Our Ref: A/88/21/NMA

**Section 96A of the Town & Country Planning Act 1990 (as amended)
Town and Country Planning (Development Management Procedure) (England) Order 2015
(as amended) - Article 10**

Non-material amendment following grant of A/38/18/RES to vary the landscaping plans approved under Condition 1 of A/38/18/RES.

Manor Nursery High Street Angmering BN16 4AW

Scale	Drawn	Approved	Date
1:250 @ A1	KM	JJ	05.03.18
Drawing No	Revision		
LLD1275-LAN-DWG-200	05

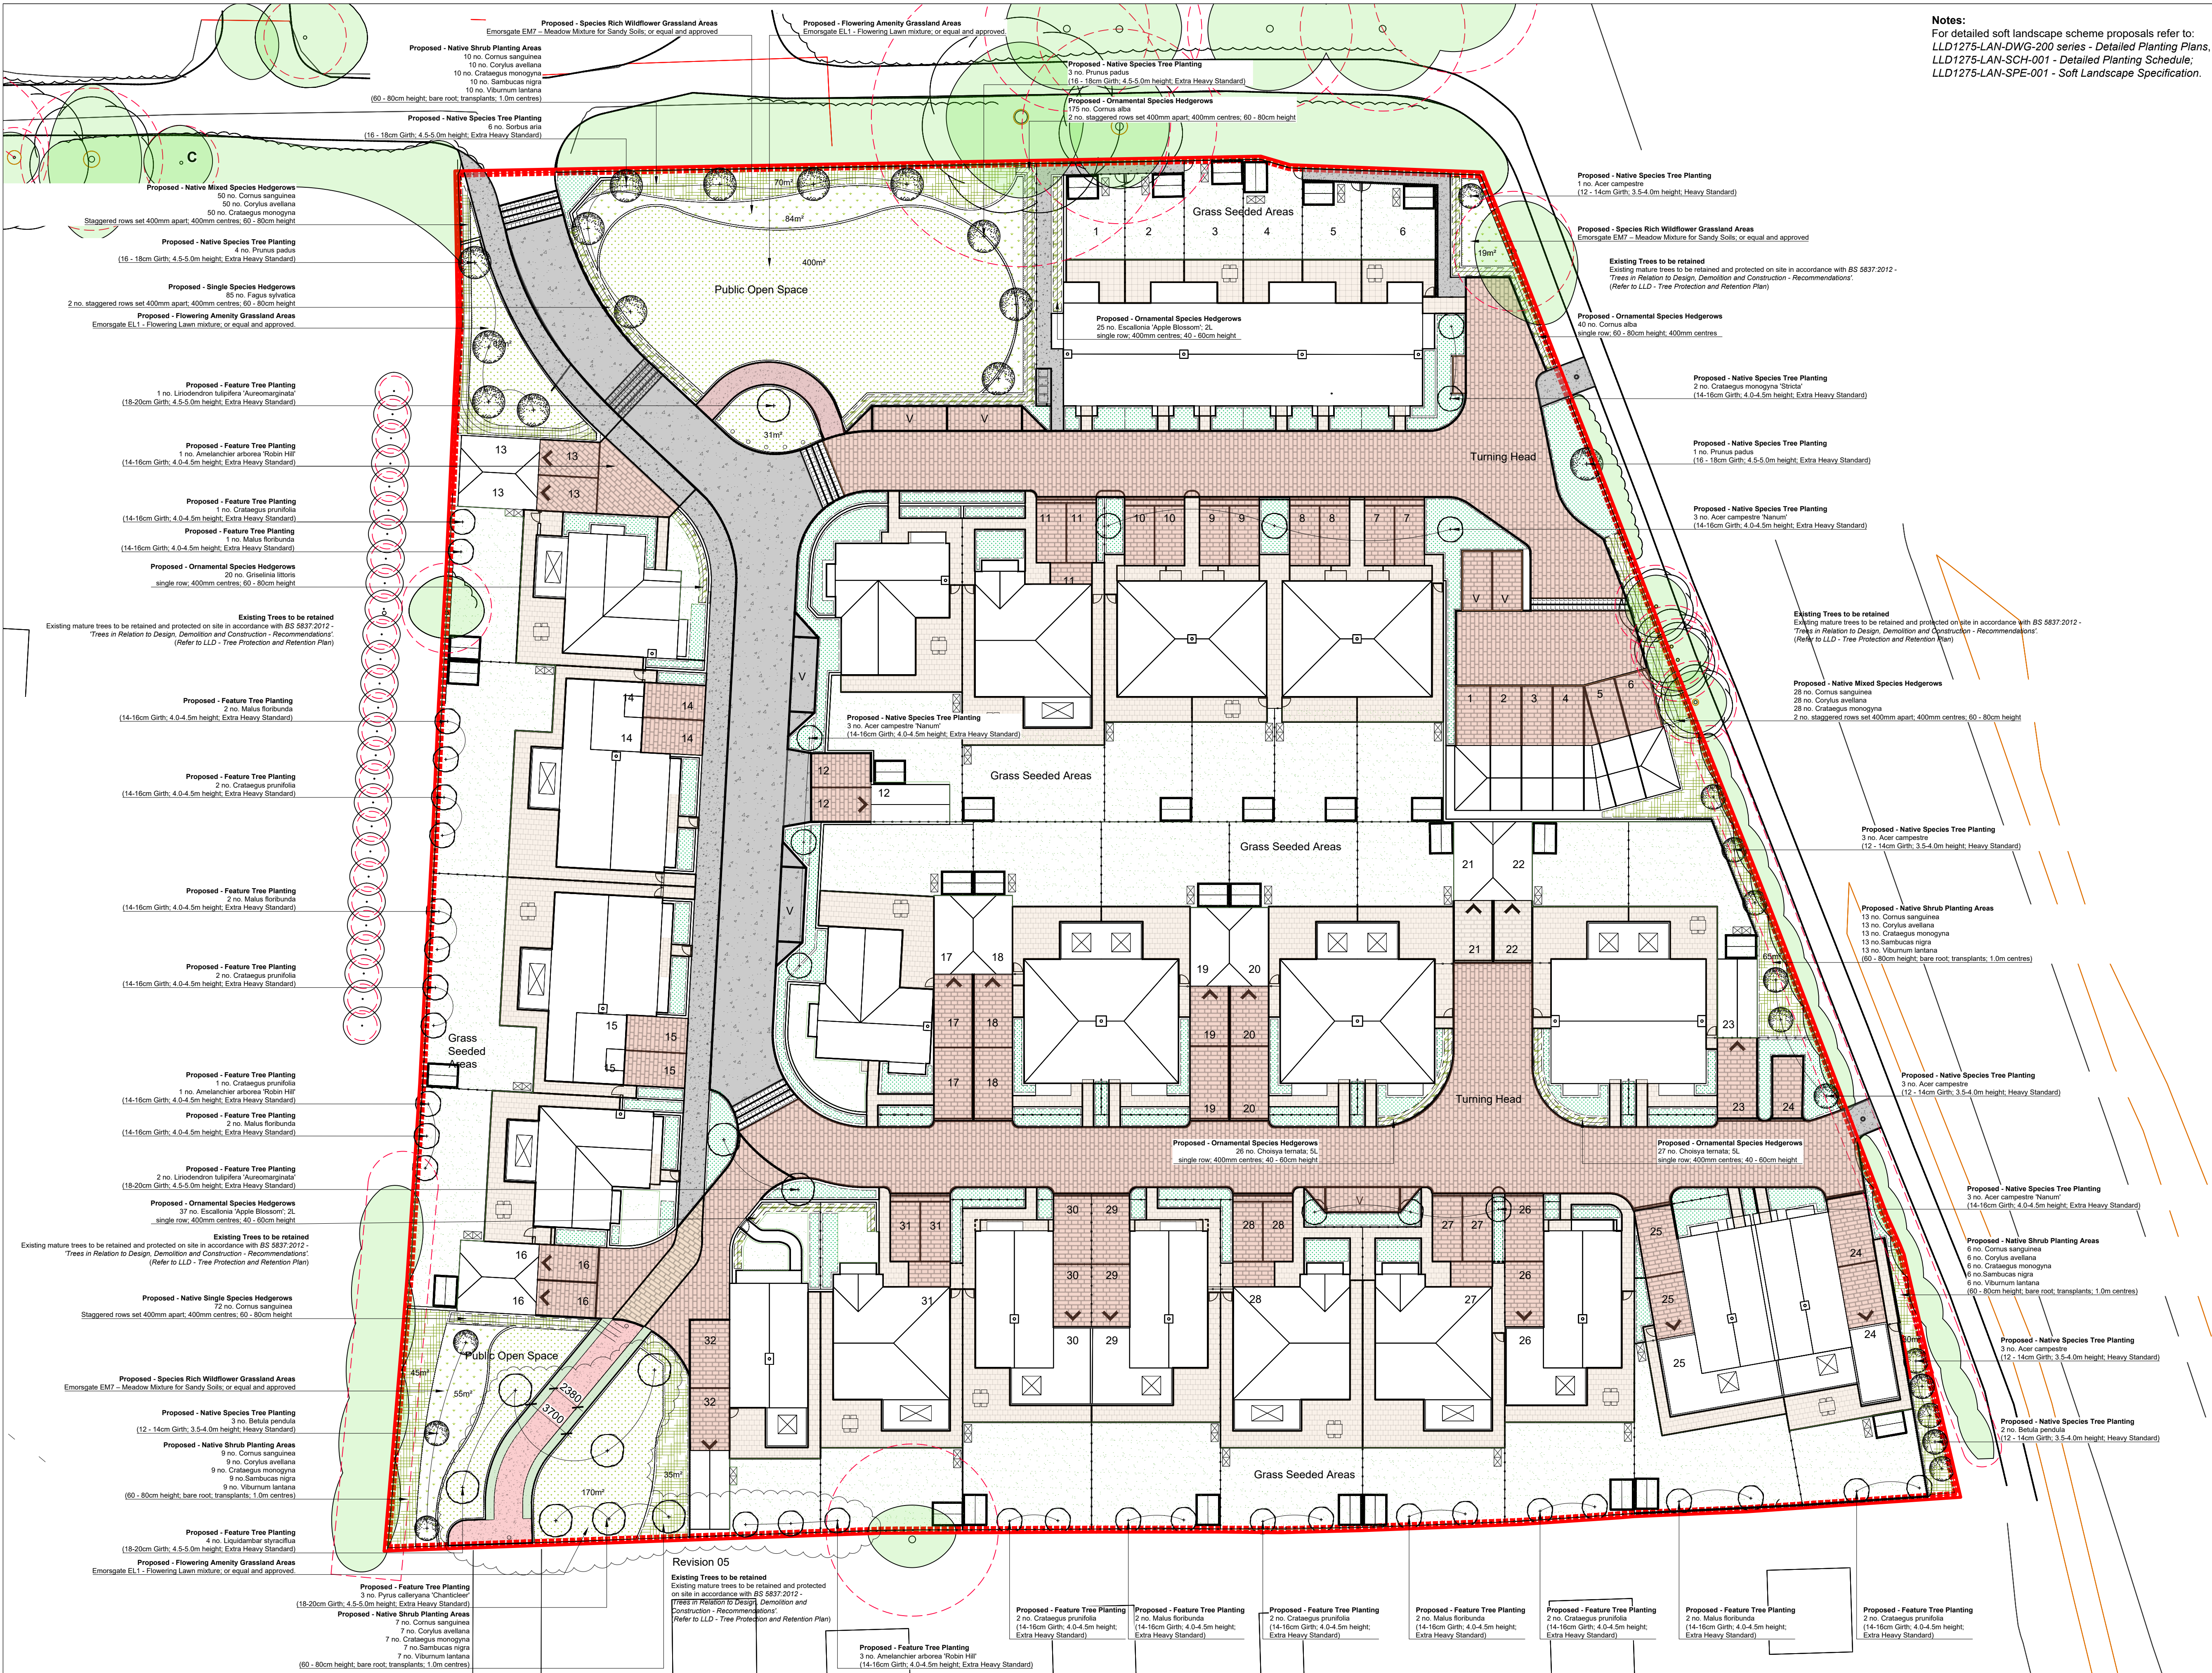
The reason that this proposal has been accepted as a Non-Material Amendment is because it is proposing to plant 3 replacement trees (Amelanchior Arborea: 'Robin Hill') in place of 3 trees which were felled inadvertently on the south western site edge, and it can therefore be considered under section 96A of the Town and Country Planning Act 1990.

Please note that Drawing No. LLD1275-LAN-DWG-100 Rev 06 - Hard and Soft General Arrangement, Drawing No. LLD1275-LAN-DWG-200 Rev. 05 - Soft Landscape Layout, and Detailed Plant Schedule and Specification (Ref. LLD-1275-LAN-SCH-001 Rev. 04), now form part of the approved planning documents and drawings for reserved matters approval

A/38/18/RES at Manor Nursery, High Street, Angmering in place of Drawing No. LLD1275-LAN-DWG-100 Rev 05 - Hard and Soft General Arrangement, Drawing No. LLD1275-LAN-DWG-200 Rev. 04 - Soft Landscape Layout, and Detailed Plant Schedule and Specification (Ref. LLD-1275-LAN-SCH-001 Rev. 03).
